An
Coimisiún
Pleanála

Inspector's Report ACP322897-25

Question	Whether alterations proposed to upgrade the thermal efficiency of the dwelling at Knockanane, Buttevant, P51DY26 is or is not development or is or is not exempted development.
Location	Knockanare, Buttevant, P51D2Y6, County Cork.
Declaration	
Planning Authority	Cork County Council.
Planning Authority Reference.	D/241/25
Applicant for Declaration	Laura Little
Planning Authority Decision	Is not exempted development.
Referral	First Party
Referred by	Laura Little
Owner Occupier	Laura Little
Observer(s)	None.
Date of Site Inspection	21 st November 2025.
Inspector	Derek Daly.

Three Bungalows for Suburban Concrete Products at Waterhouse

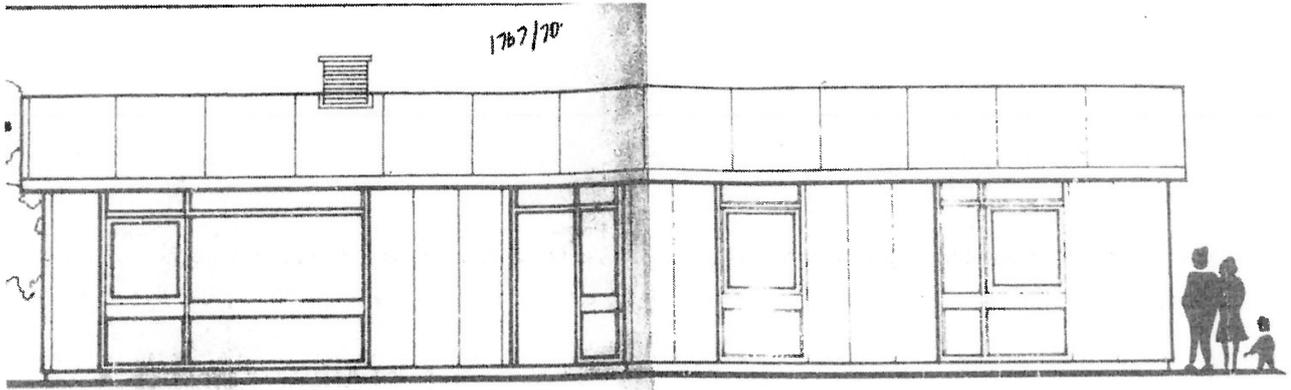
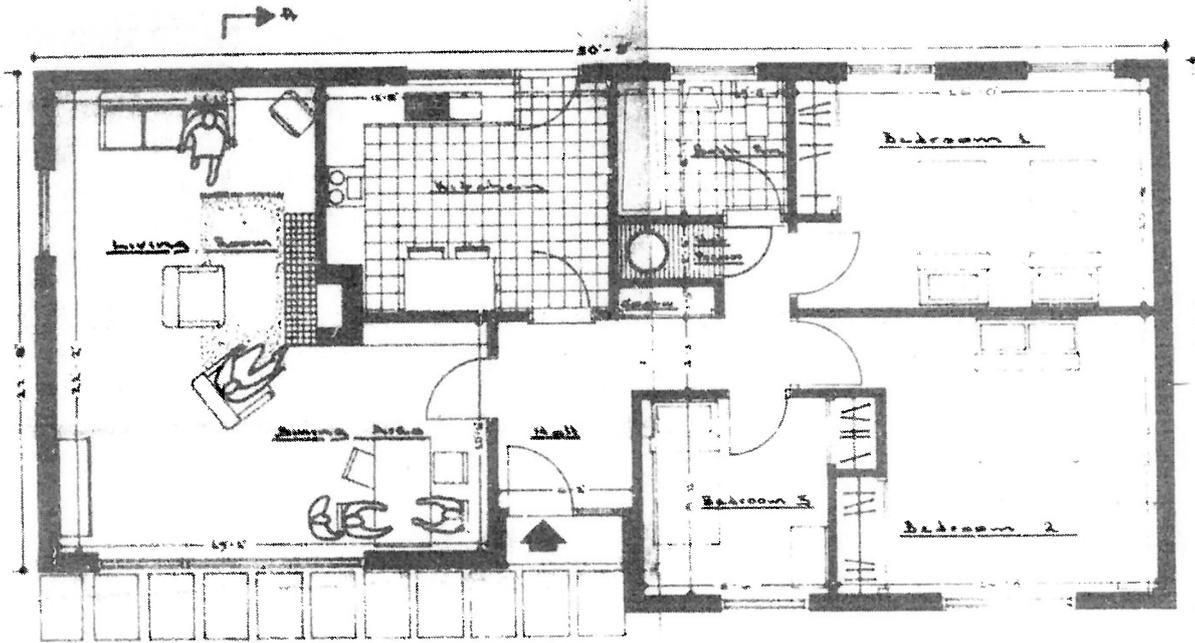
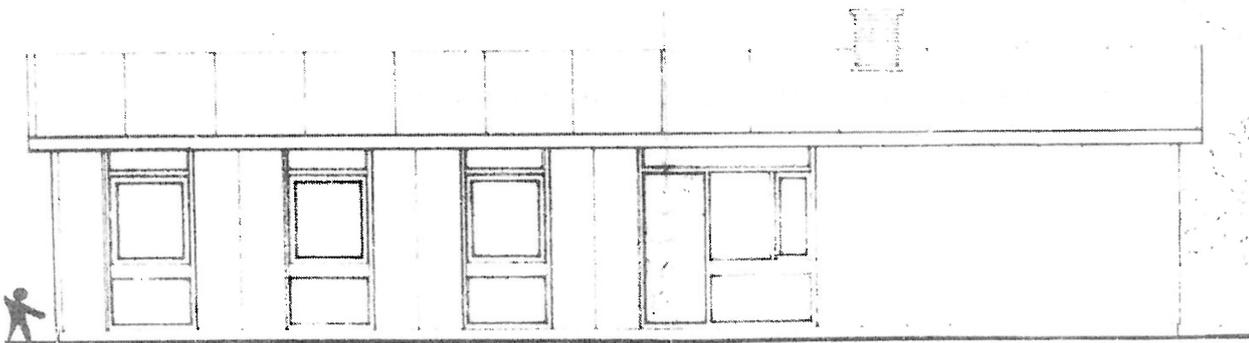
- 8.3.7. I have reviewed the drawings associated with 70/1767.
- 8.3.8. The dwelling on the site is handed in comparison to the drawings as submitted, but the position of the doorway is central to the elevation and there are two window openings on one side of the doorway and a single window opening on the other side of the doorway. The windows differ in being smaller and not extending downwards towards the plinth as would appear to be indicated on the drawings but retain the same approximate width. In relation to the roof the dwelling as constructed has a hip roof construction as distinct to a straight gable to eaves height.

- 8.3.9. The primary variations between the permitted and constructed dwelling in relation to external appearance of the structure are in relation to the windows and the shape/construction of the roof and the matter to be considered is whether the variations are material.

- 8.3.10. In relation to the windows, they are not an increase in the area of glazing, are smaller in area and of a lesser overall height than the drawings of the permitted dwelling. I do not consider that the variations materially affect the external appearance of the structure so as to render the appearance inconsistent with the character of the structure or of neighbouring structures and the works in question are works which can be considered do not materially affect the external appearance of the structure so as to render the appearance inconsistent with the character of the structure or of neighbouring structures and therefore meet the requirements of s.4(1)(h).

- 8.3.11. The roof construction is different incorporating a hip design but the overall height and pitch is similar. I do not consider the variation materially affect the external

appearance of the structure so as to render the appearance inconsistent with the character of the structure or of neighbouring structures

- 8.3.13. To conclude on this matter although there is variation from the original drawings as stated the glazed area of the windows is reduced rather than increased and the overall scale and height of the roof has not significantly altered and significantly increased in height and do not materially affect the external appearance of the structure. I also do not consider the dwelling as constructed are works such so as to render the appearance inconsistent with the character of the structure or of neighbouring structures. There is nothing therefore to suggest that the works referred to in the question are not exempted development on a structure/dwelling where planning permission was granted and or in relation to any subsequent works which would comply with the provisions of section 4(1)(h).
